WEST SUSSEX COUNTY COUNCIL CONSULTATION

TO:	Arun District Council FAO: Amber Willard
FROM:	WSCC - Highways Authority
DATE:	16 December 2019
LOCATION:	29 Westfield Bognor Regis PO22 9HE
SUBJECT:	BE/117/19/HH Drop kerb to front of property with works to existing wall.
DATE OF SITE VISIT:	n/a
RECOMMENDATION:	More Information
S106 CONTRIBUTION TOTAL:	n/a

South east elevation as proposed and showing works to wall 1:100

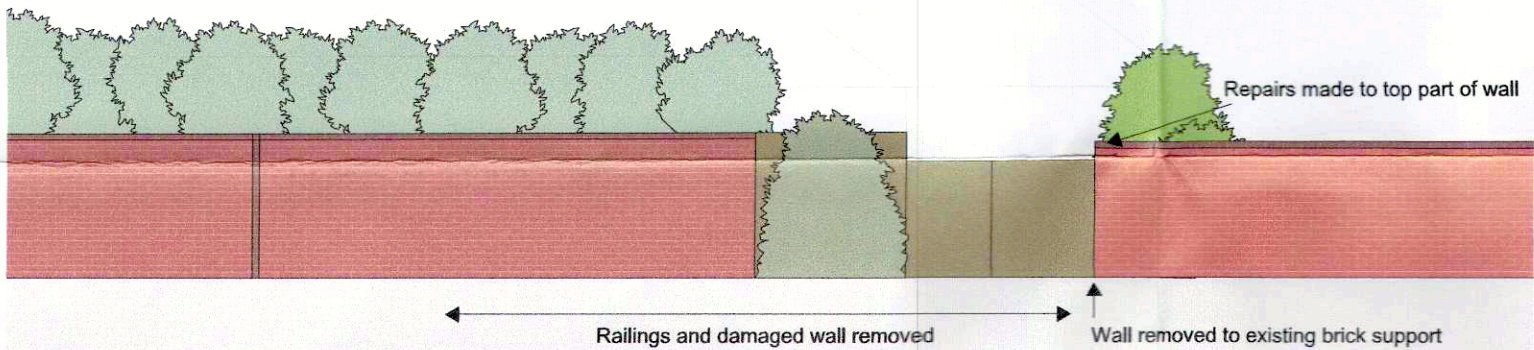
The applicant proposes to implement a 5.2-metre VCO. While the Local Highways Authority (LHA) raise in principle no highways safety concerns, we observe that the access would benefit from the lowering of the 'outer' wall (closest to Rowans Way) to a maximum of 0.6 metres in height for 2 metres from the eastern side of the access point. This would provide adequate visibility of pedestrians from vehicles entering the access point from Rowan Way.
